**Southern
Water**

Our ref
PLAN-028651

Proposal: Single storey rear extension.

Site: AL/53/19/HH:- 32, St Richards Road, Westergate, PO20 3RD.

Proposed

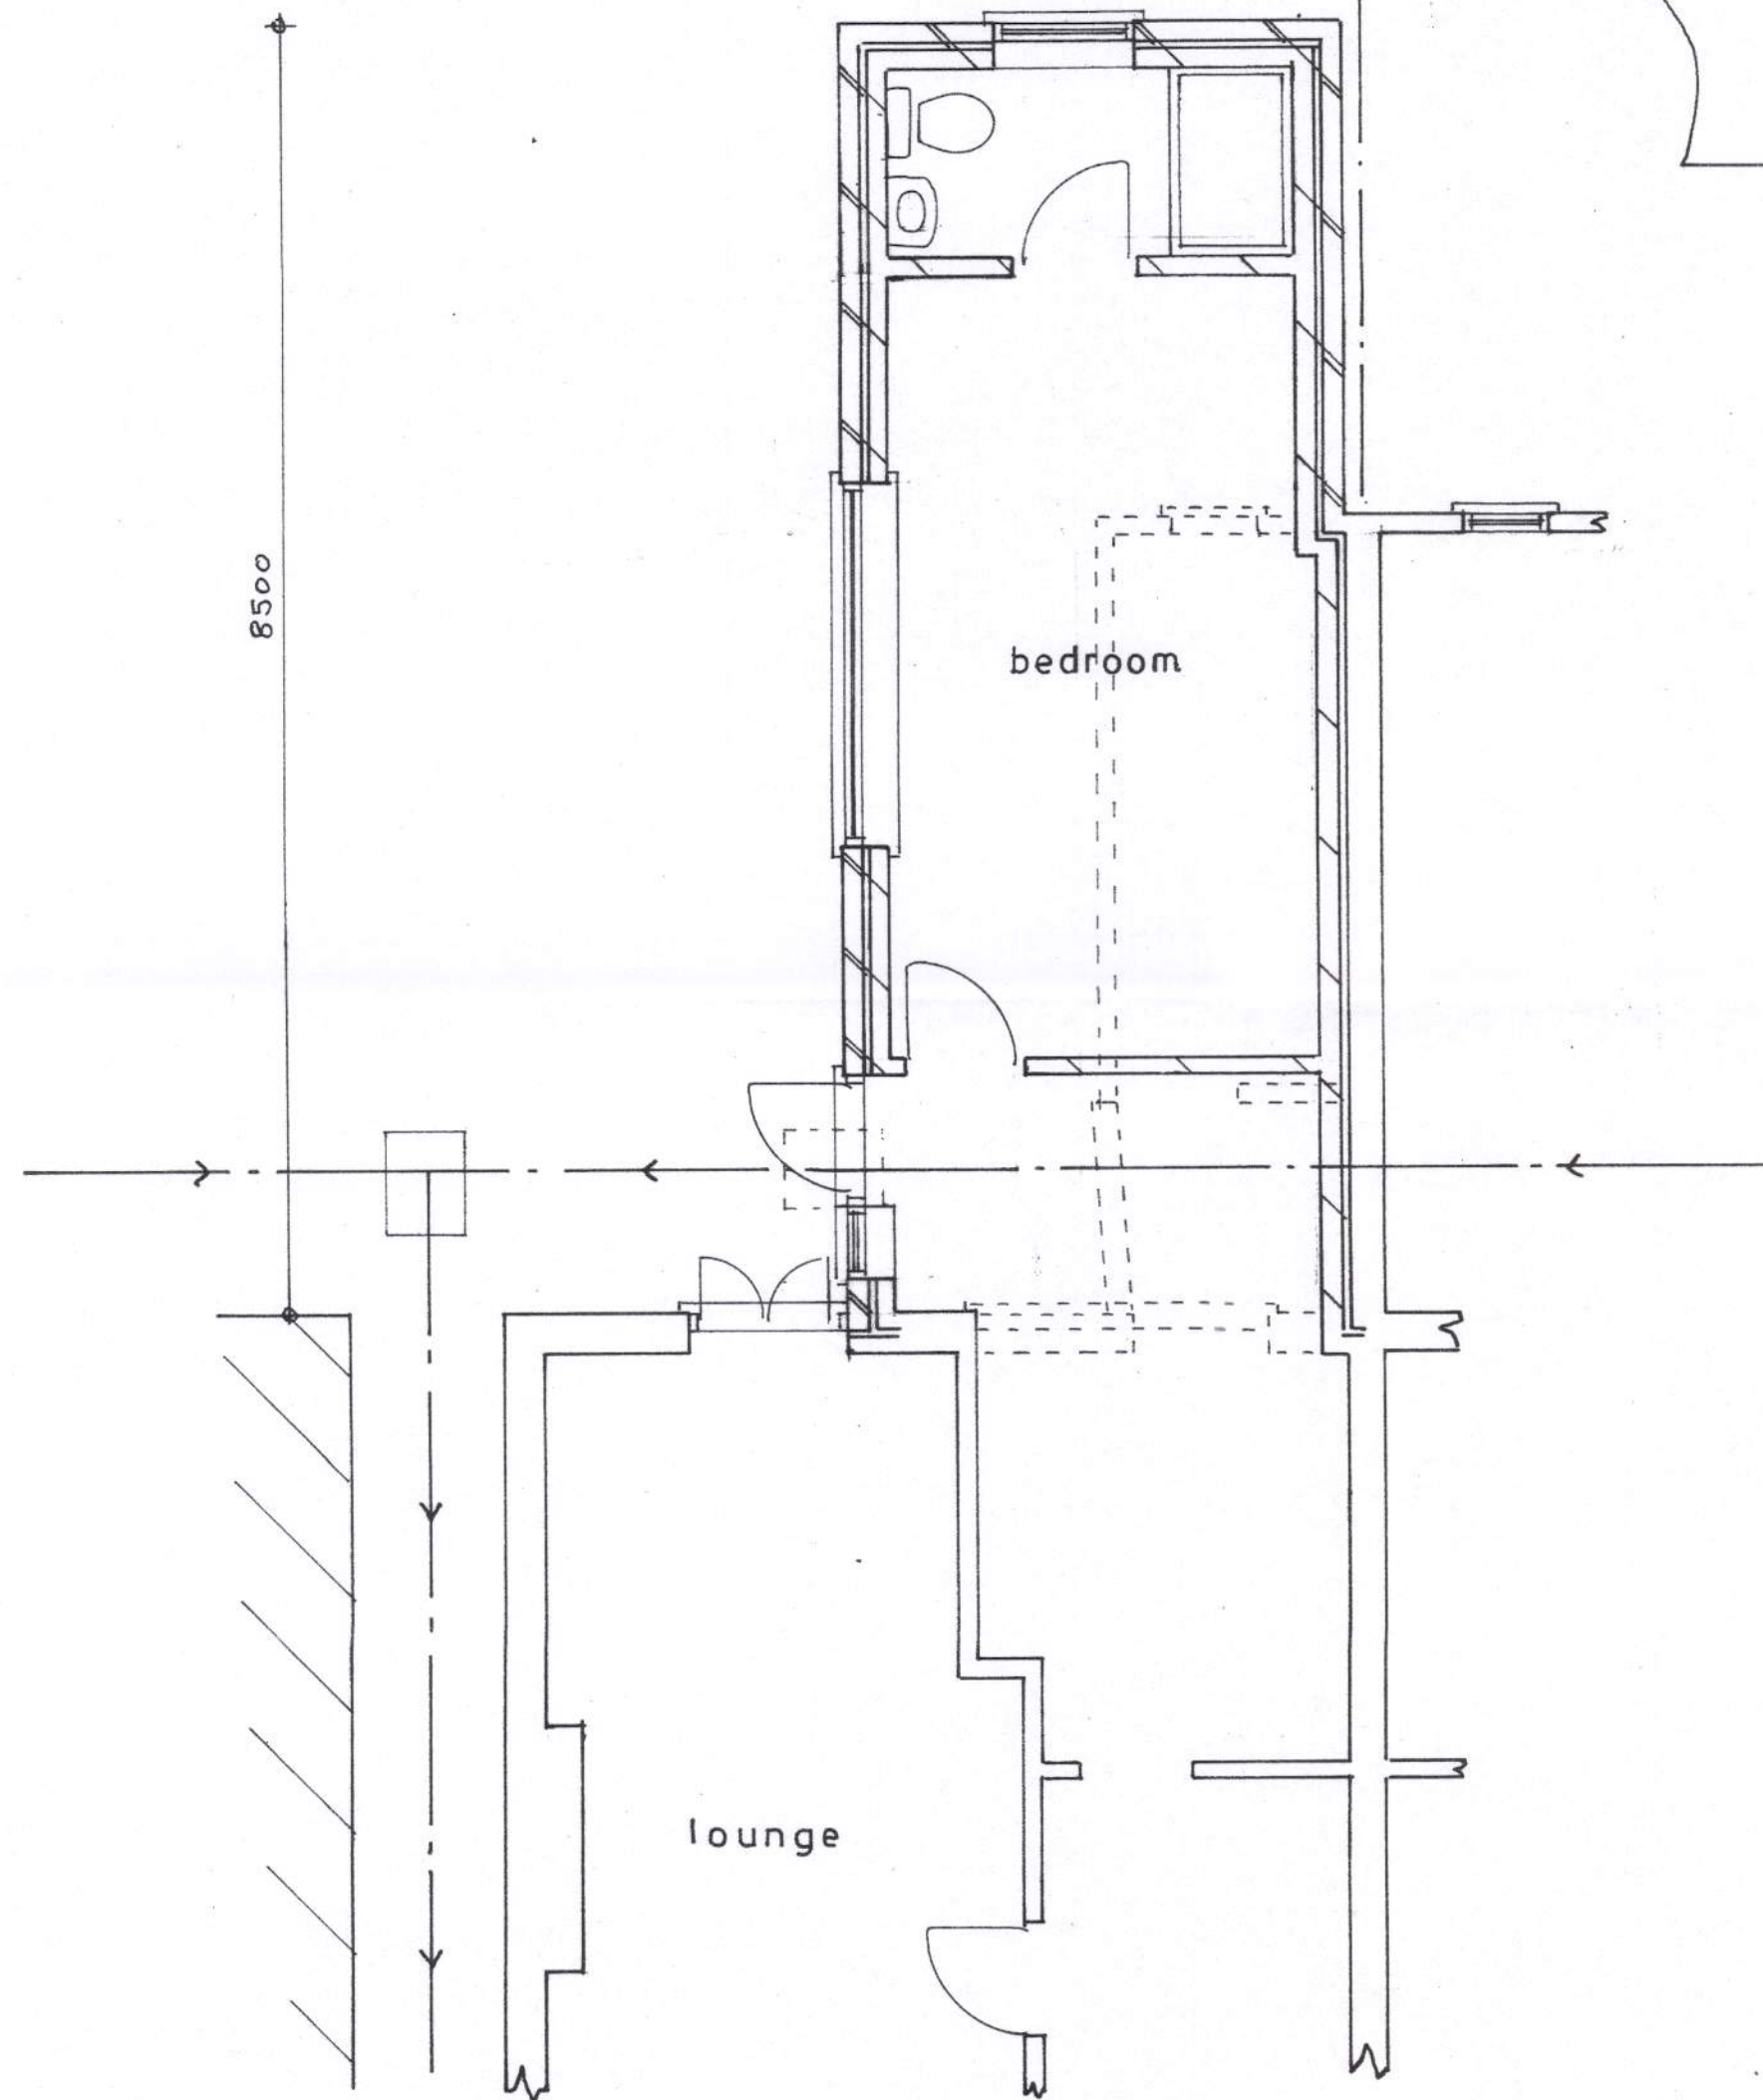
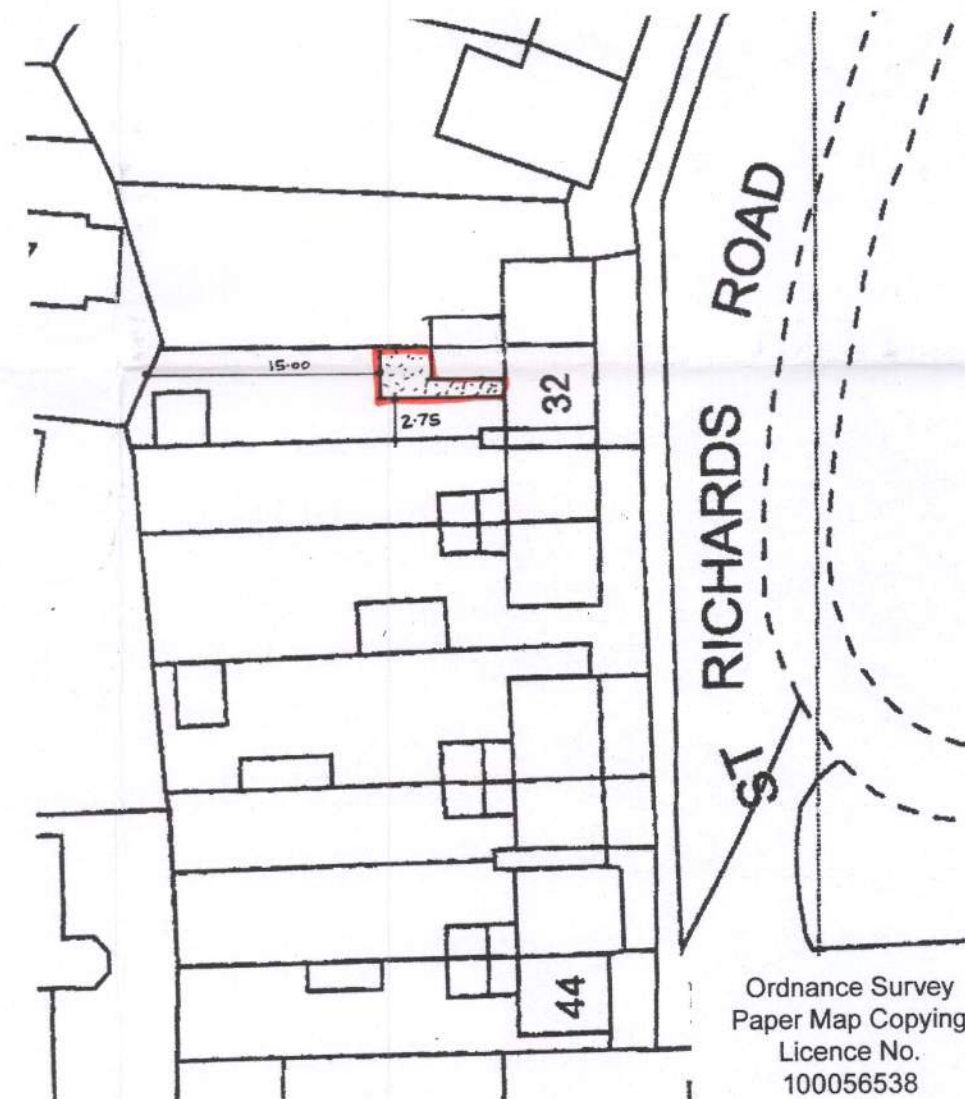
Submitted plan shows the proposed extension lies over an existing sewer serving neighboring property and crossing the proposed site (not shown on our records). An investigation of the sewer is required to ascertain its condition.

Building over a "public sewer" is not normally permitted by Southern Water. However, under certain circumstances building over a sewer may be allowed. The conditions associated with the buildover to a sewer are contained in Southern Water guidance notes which are available at: www.southernwater.co.uk. A formal application to build over to the sewer will required to be submitted by the applicant.
